Ribble Valley Borough Council
Housing & Development Control

Application no: **3/2019/0188/FUL**

Address: **17 Ribblesdale View Chatburn BB7 4BB**

Proposal: **Application for a two storey side extension.**

Drawing Number **235 / PL20**

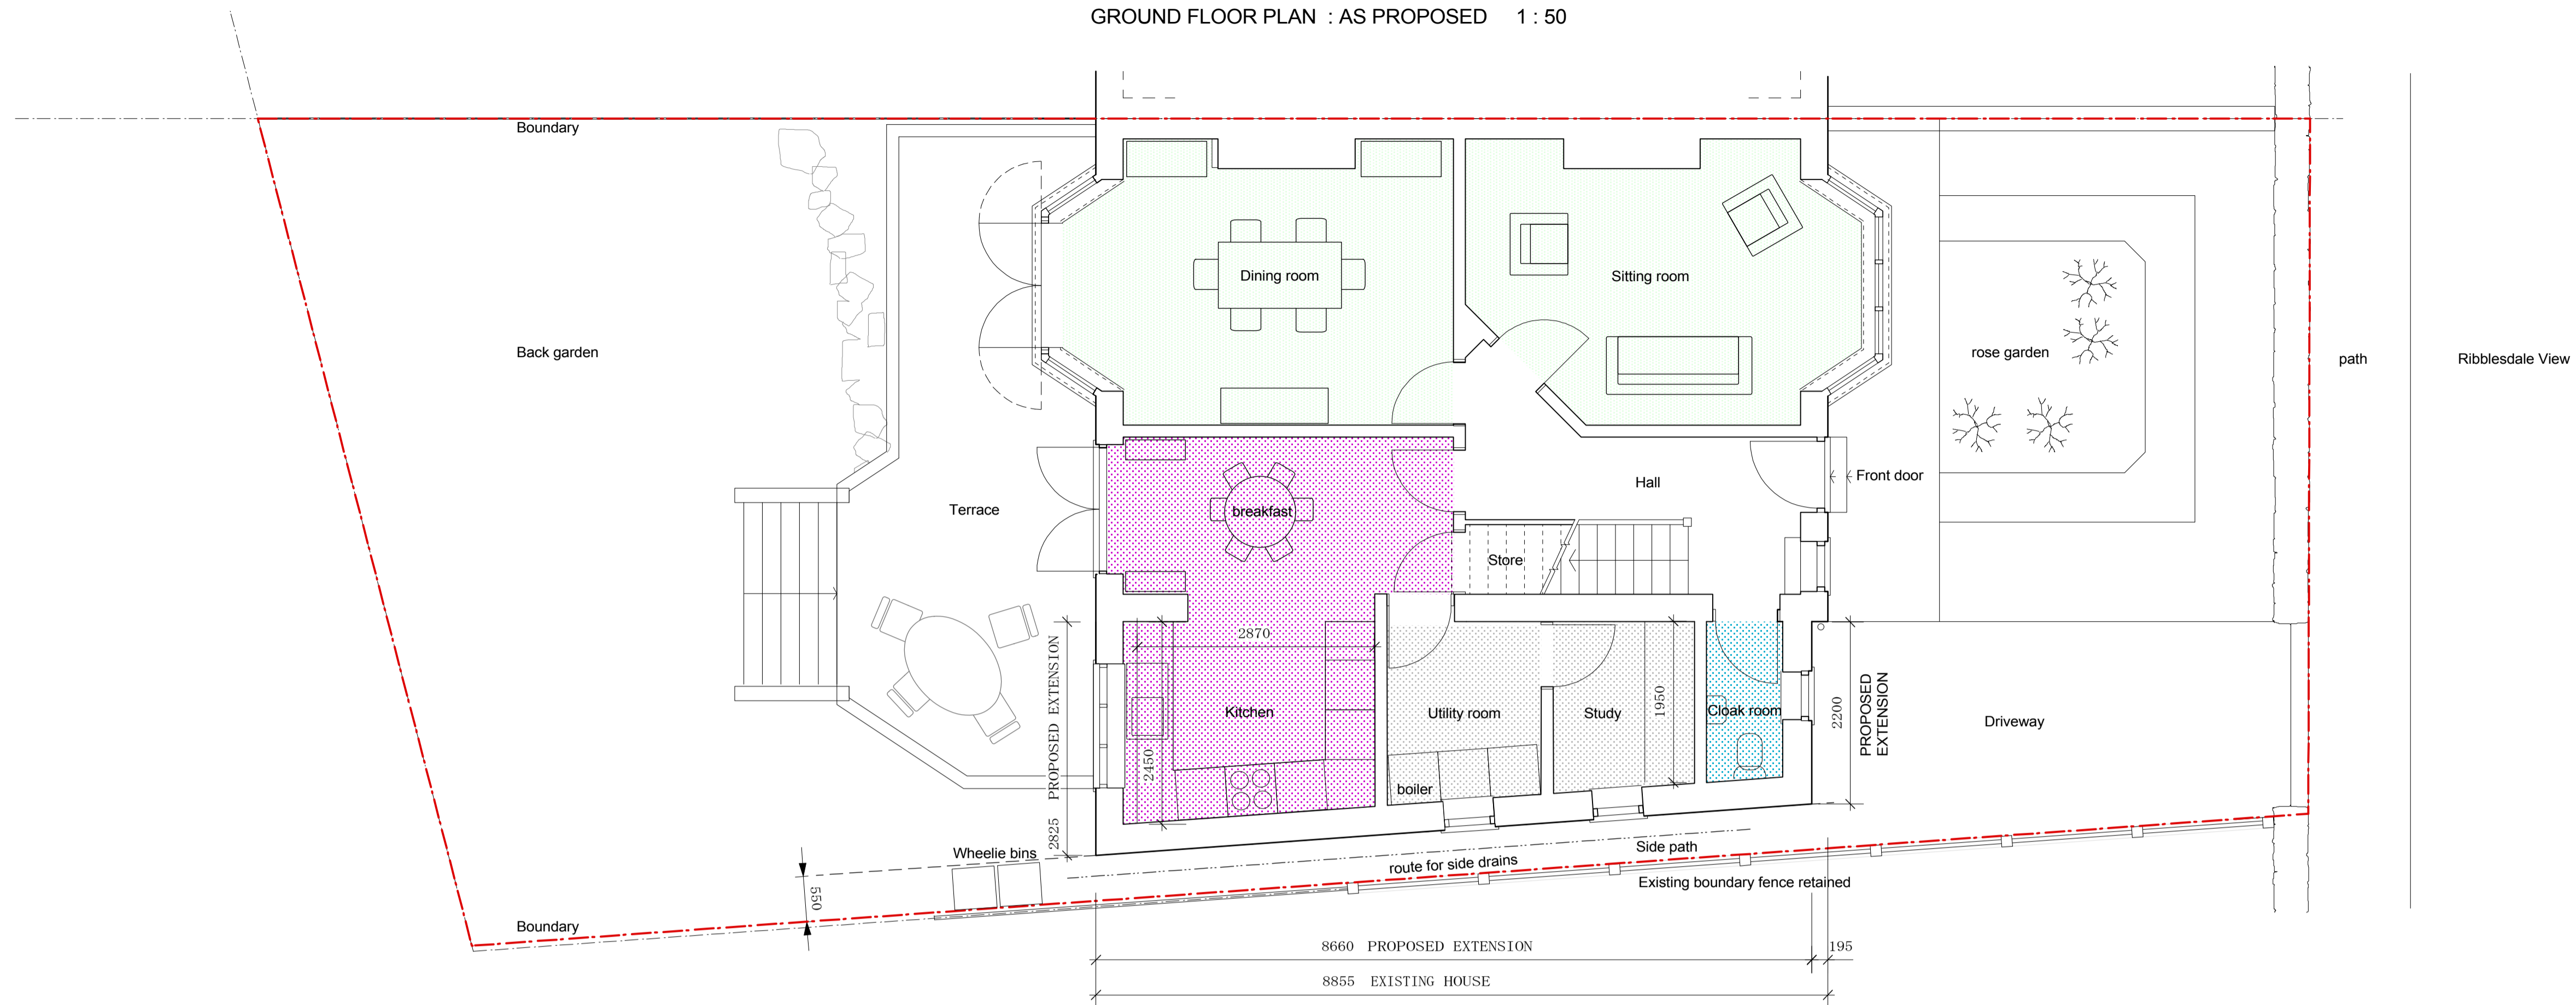
The revised layout in accordance with drawing number 235/PL20A demonstrates there will be a sufficient parking provision to support the proposal, however the proposed parking formation will need to be bound using an approved surfacing material as well as an extension of the existing drop kerb that will need to be installed prior to the commencement of any external works in accordance with the full approval of this application whereas these works shall be carried out under section 184 of the Highways Act 1980.

The existing boundary wall is proposed to be widened by 1.9m and as a result an extension of the drop kerb will need to be installed prior to work commencing in accordance with the full approval of this application.

1. Before the area fronting the dwelling is used for vehicular purposes, the area to be used as parking shall be appropriately paved in tarmacadam, concrete, block pavements, or other approved materials. **Reason:** To prevent loose surface material from being carried on to the public highway thus causing a potential source of danger to other road users.
